Stonestreet Green Solar

Signed Statement of Common Ground with the Environment Agency (Tracked)

Doc Ref. 8.3.2(B)

Version 3

- Notes:**
- All hedgerow reinforcement planting to be done within the DCO boundary.
- Legend:**
- ORDER LIMITS
 - EXISTING SURVEYED TREES AND VEGETATION
 - EXISTING WATERCOURSES AND FEATURES

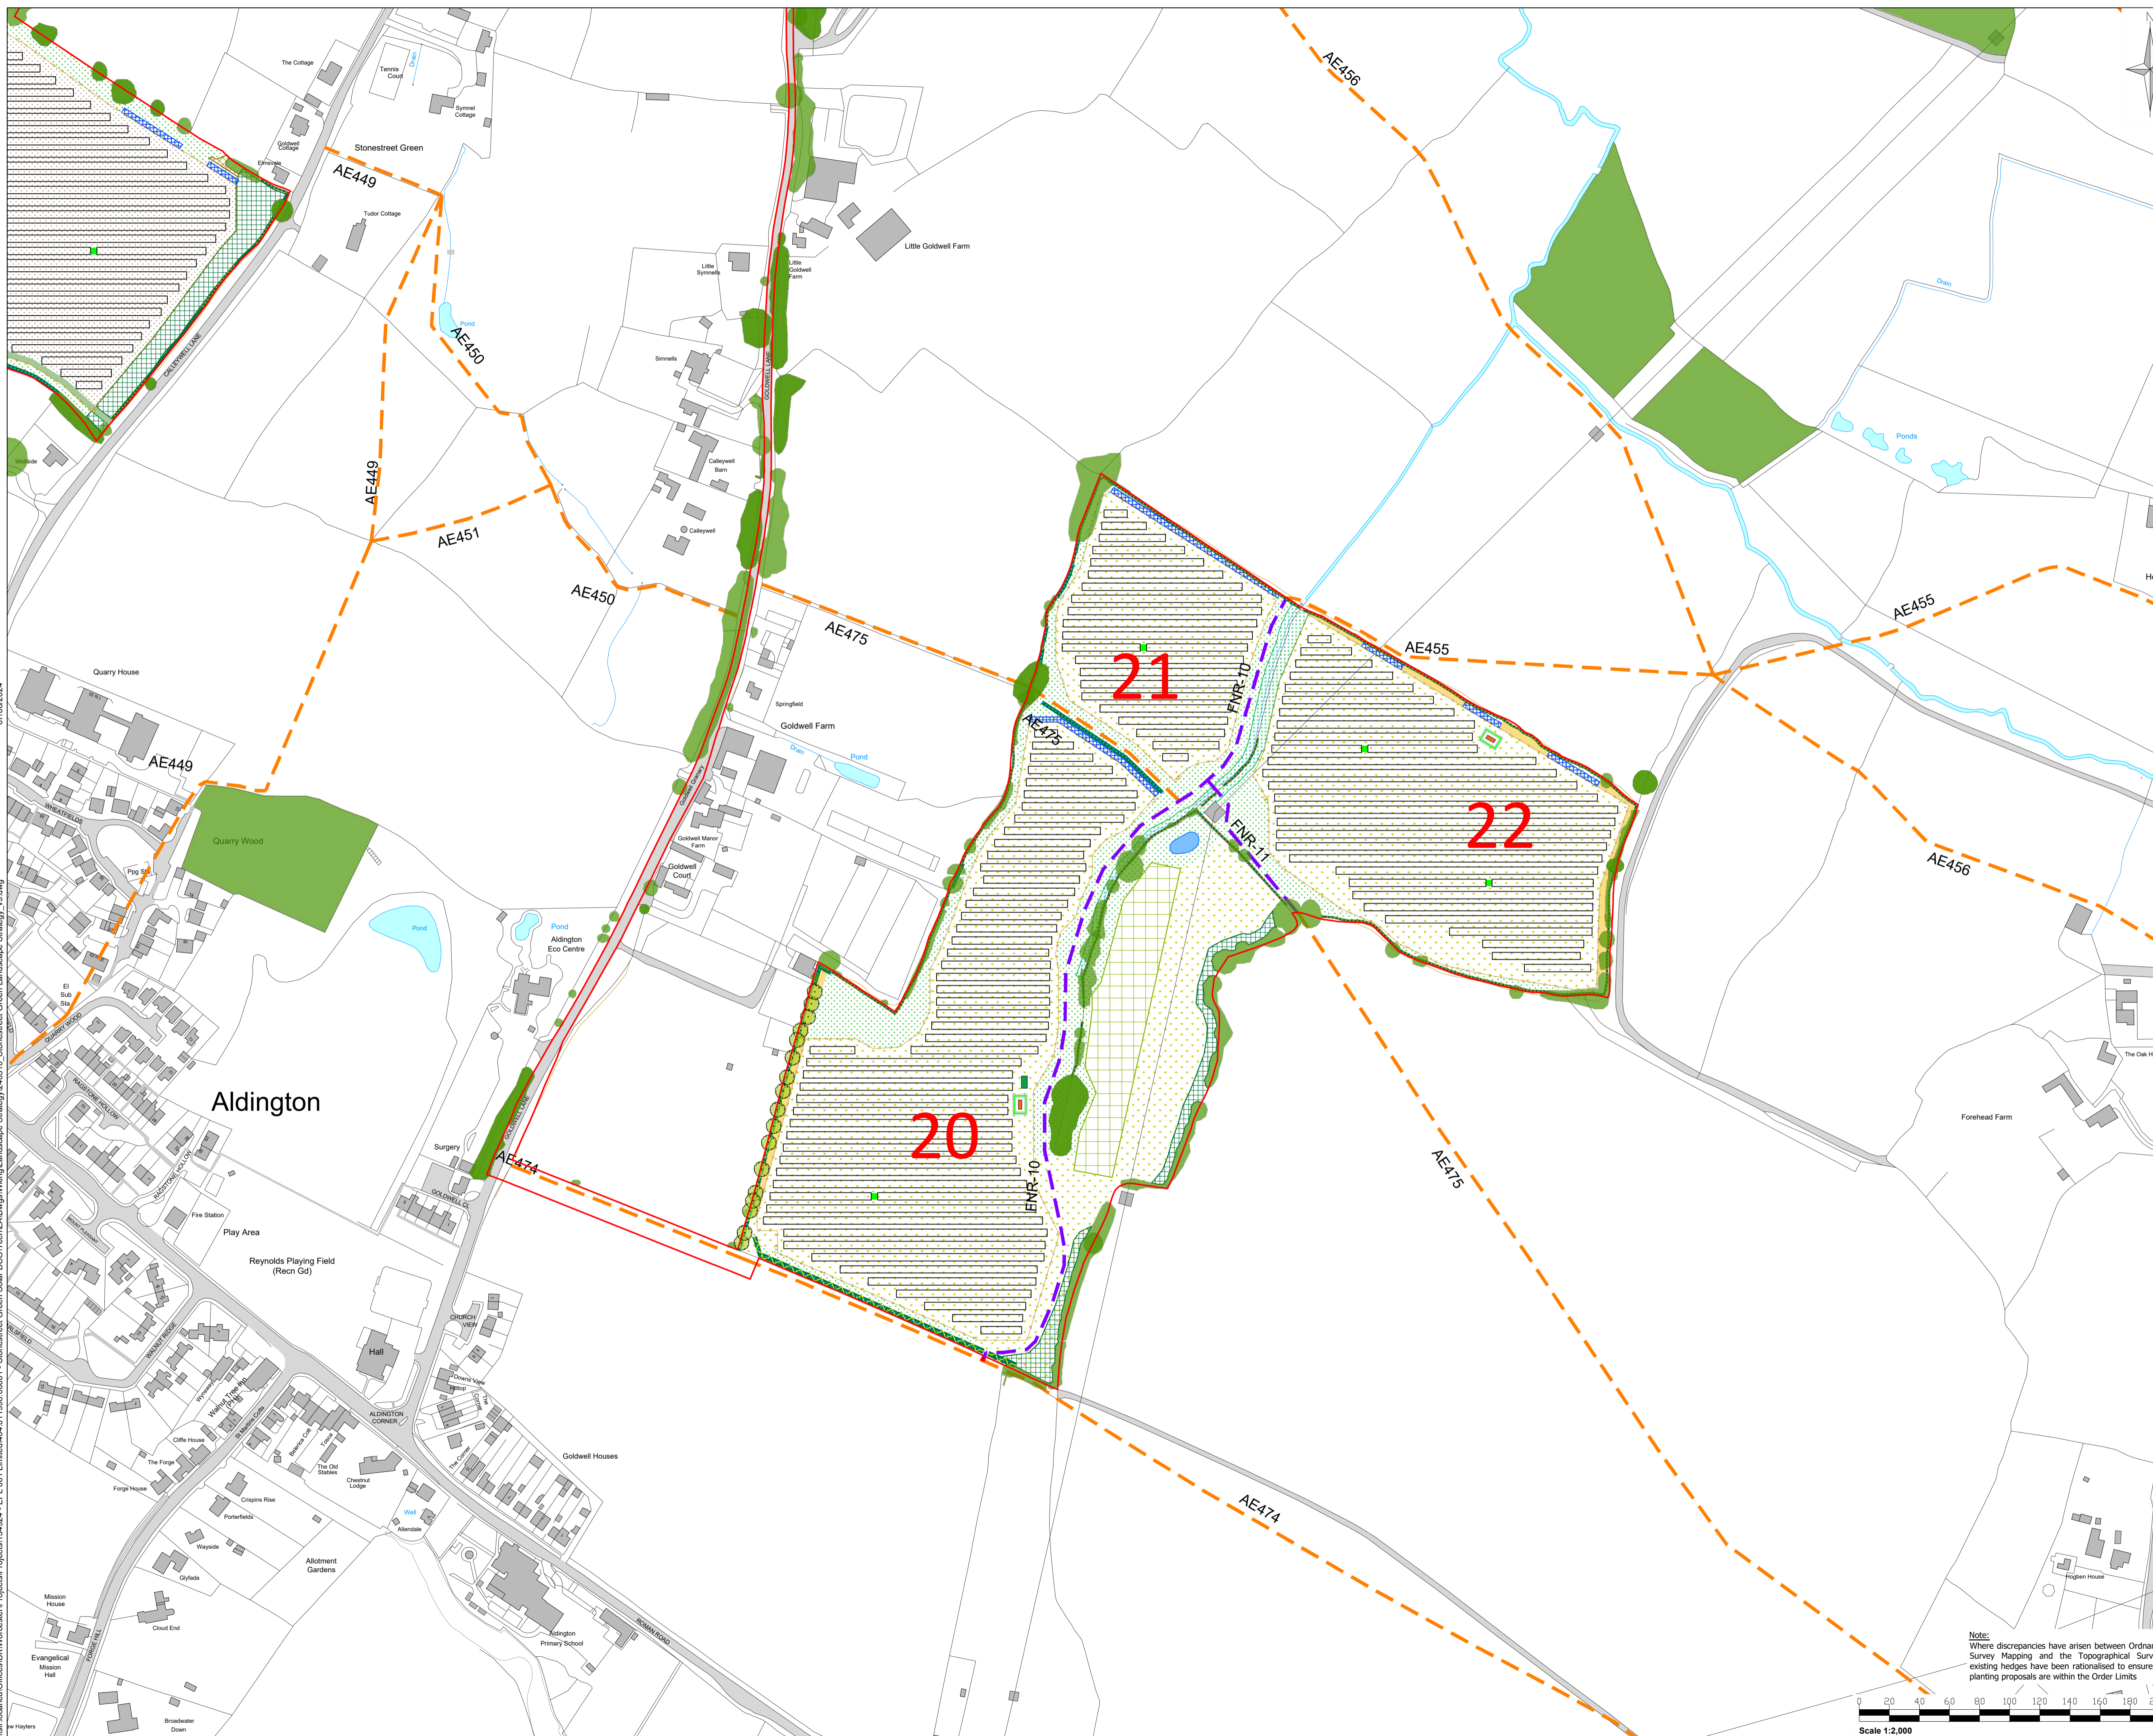
Ref	Relevant Application Document	Description of Matter	EA Current Position	Applicant's Current Position	Status
2.10 to 12	RR	Issue 3 - Flood Storage Calculations	Situation: The 'Floodplain Compensation level for Level Calculation' table from 'Annex D: Floodplain Compensation Level for Level Calculations' of the FRA demonstrates a net increase (1,543.11 m3) in flood storage downstream of the Aldington Flood Storage Area but does not show any net increase within Aldington Flood Storage Area as referenced in the Outline Operational Surface Water Drainage Strategy (OOSWDS). Paragraph 5.1.5 of the OOSWDS states "The swale and wetland areas have both been designed to enhance biodiversity and ensure that there is no adverse impact on water quality. In addition, the wetland area, which will be sited within the AFSA, will increase the capacity of fluvial flood storage available. This will therefore contribute to a small reduction in downstream flood risk." (<i>APP-094 – Doc 5.4 Environmental Assessment Appendix 10.2: Flood Risk Assessment; APP-159 – Doc 7.14</i>)	None of the works proposed within the AFSA involve any build up in ground levels. The works proposed relate to; 1. Superficial treatments and vegetation management with a commitment made that vegetation management will be ongoing with any accumulated material removed from the AFSA. Such work would therefore have a neutral impact on flood storage, 2. The provision of fencing around the skylark area in Field 29 as illustrated on the Illustrative Landscape Drawings (Doc Ref. 2.7(A)) [REP1-005]2.7(B)) (Sheet 3 of 5 - drawing number 011998.00001.712). The fence posts would result in a negligible loss of flood storage, but at a level that would be difficult to quantify. 3. The creation of ecological scrapes and ponds as illustrated on the Illustrative Landscape Drawings (Doc Ref. 2.7(A)) [REP1-005] (Sheet 3 of 5—	Under discussion Agreed

Ref	Relevant Application Document	Description of Matter	EA Current Position	Applicant's Current Position	Status
			<i>Outline Operational Surface Water Drainage Strategy</i> Impact: The storage capacity of Aldington Flood Storage Area may be reduced by the proposed landscaping works. Solution: The applicant should amend the flood storage calculations within the 'Floodplain Compensation level for Level Calculation' table from 'Annex D: Floodplain Compensation Level for Level Calculations' of the FRA to show the flood storage increase inside Aldington Flood Storage Area as stated in the paragraph 5.1.5 of the OOSWDS "increase the capacity of fluvial flood storage available". 22/11/2024 (EA) As outlined above when the Outline OSWDS (Doc Ref. 7.14) is updated to include that there will be no net loss of storage capacity within the AFSA this will be conditioned. We have no further comments to make until we have reviewed the requested supporting calculations and updates to Environmental Statement	drawing number 011998.00001.712.2.7(B)) (Sheet 3 of 5 - drawing number 011998.00001.712). These would be formed by excavation only with all spoil removed disposed of outside of the AFSA. As such these works would only increase the available flood storage volume. 4. The creation of the wetland area which will receive storm runoff from the Project Substation. This will be formed by excavation and will not involve impounding water to a level above the existing ground surfaces. As such the formation of this feature can only increase the volume of flood storage available. The net effect of these works will clearly be an increase in the available flood storage volume within the AFSA. On this basis no further assessment was deemed necessary. In response to this comment work is however now being undertaken to quantify the changes resulting from items 2, 3 and 4 above. This

Ref	Relevant Application Document	Description of Matter	EA Current Position	Applicant's Current Position	Status
2.13	RR	Issue 3 - Flood Storage Calculations	Solution: The applicant should also confirm that there is no loss of flood storage capacity in Aldington Flood Storage Area from the landscaping works including but limited to the woodland planting, tree planning, habitat scrapes and habitat ponds. 22/11/2024 (EA) No further comments, our above comments for Issue 2.10 to 12 apply. <u>16/01/2025 (EA) We have reviewed the updated Flood Risk Assessment (FRA) (Doc Ref. 5.4(A)) dated December 2024 and we are satisfied with it. Our above comments for Issue 2.10 to 2.12 apply. Status changed as "Agreed"</u>	As above	<u>Under discussion</u> <u>Agreed</u>

Ref	Relevant Application Document	Description of Matter	EA Current Position	Applicant's Current Position	Status
			Appendix 10.2: Flood Risk Assessment (Doc Ref 5.4) <u>16/01/2025 (EA) We have reviewed the updated Outline OSWDS (Doc Ref. 7.14(A)) dated December 2024 which now includes commitment in section 4.6.8 that the Project would not result in a net loss of storage capacity with the AFSA.</u> <u>Section 4.6.8 of the Outline OSWDS states "The wetland area also provides the benefit of creating additional storage within the Aldington Flood Storage Area. This effect is quantified in ES Volume 4, Appendix 10.2: Flood Risk Assessment (Doc Ref. 5.4). The final detailed design for this feature, and other small ecological ponds and scrapes, will ensure that there is a net increase in flood storage provided within the Aldington Flood Storage Area." We are satisfied with the changes to the Outline OSWDS.</u>	additional detail will be included within ES Appendix 10.2: Flood Risk Assessment (Doc Ref 5.4(A)) [REP1-036] [REP1-037] and [REP1-038]. The updated document will be provided by Deadline 1. In addition, the Applicant will also amend the Outline OSWDS (Doc Ref. 7.14(A)) [REP1-054] 7.14(B)) to include a commitment to ensure no net loss of storage capacity within the AFSA. The Applicant awaits the EA's confirmation that the updates to the Outline OSWDS (Doc Ref. 7.14(A)) [REP1-054] are acceptable. 7.14(B)) <u>are acceptable.</u>

Ref	Relevant Application Document	Description of Matter	EA Current Position	Applicant's Current Position	Status
			<u>Additionally, we have reviewed the updated Flood Risk Assessment (FRA) (Doc Ref. 5.4(A)) dated December 2024 which now includes level for level flood storage calculations for the land upstream of the AFSA embankment shown in Appendix D 'Upstream of AFSA Embankment: Floodplain Compensation Level for Level Calculations'. Section 11.3.9 of the FRA states "flood storage is increased within the ASFA by 1,684m3." We are satisfied that the FRA now shows a net increase in flood storage capacity within Aldington Flood Storage Area.</u> <u>We note that the Environment Agency has been added as a statutory consultee for the approval of the Detailed OSWDS secured by Requirement 11 of the Draft DCO (Doc Ref. 3.1(C)) which we are satisfied with.</u> <u>Status changed to "Agreed".</u>
